From: G. A. Raven 
Sent: 09 July 2021 10:26
To: Daniel Vick <Daniel.Vick@arun.gov.uk>
Cc: Neil Crowther <Neil.Crowther@arun.gov.uk>
Subject: 27,Central Drive

Leaving aside the relatively minor corrections to link extension, privacy screen, windows and finishes, the main significant part of the application is to delete the misleading street scene as a relevant document. No mention is made of the original elevations which were similarly misleading – albeit more authoritatively. I note however that revised elevations are provided which, unsurprisingly, unlike the originals which (see my emails of 3/7/21 and 11/7/21) should have been a significant part of the original considerations, do not show the relationship with the height of the neighbouring property.

PROJECT	27 Central Drive - Elmer Beach	DATE	16/09/18
TITLE	Proposed South Elevation	DRG NO	IBA/507/05
SCALE	1 : 50	REVISIONS	B

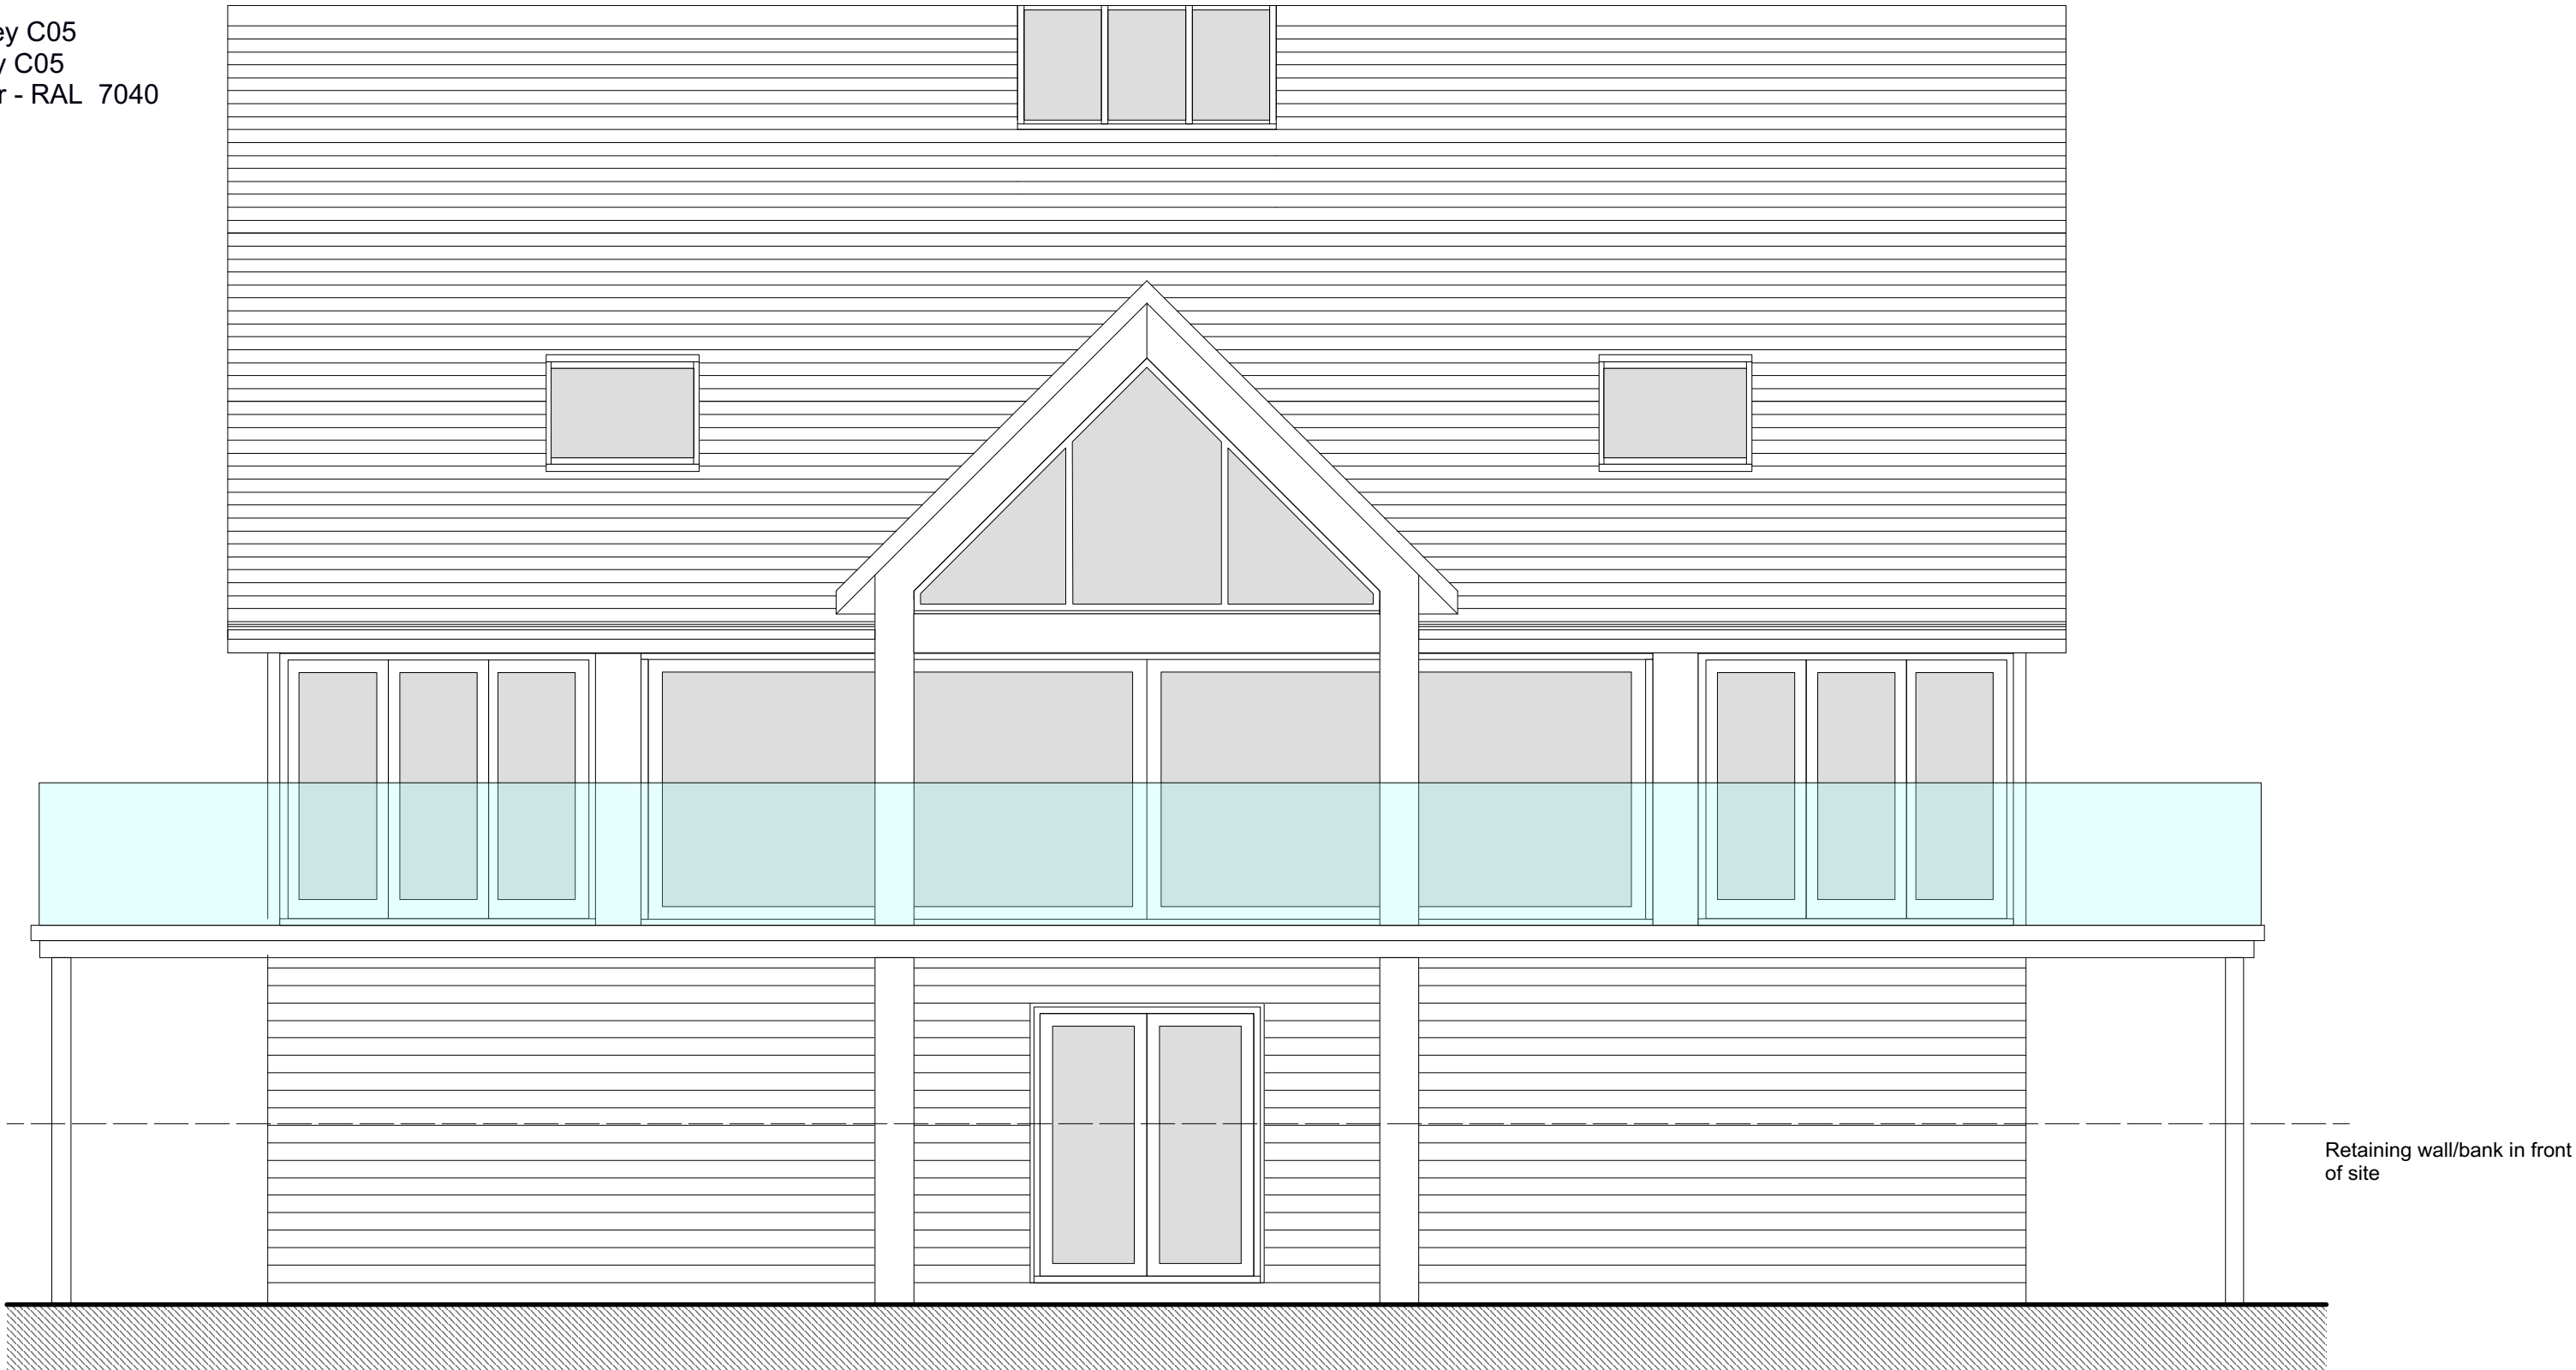
There is in fact in the revised application no acknowledgement of any controversy regarding the overall height. Again this is unsurprising given the Council's apparent acquiescence in this matter.
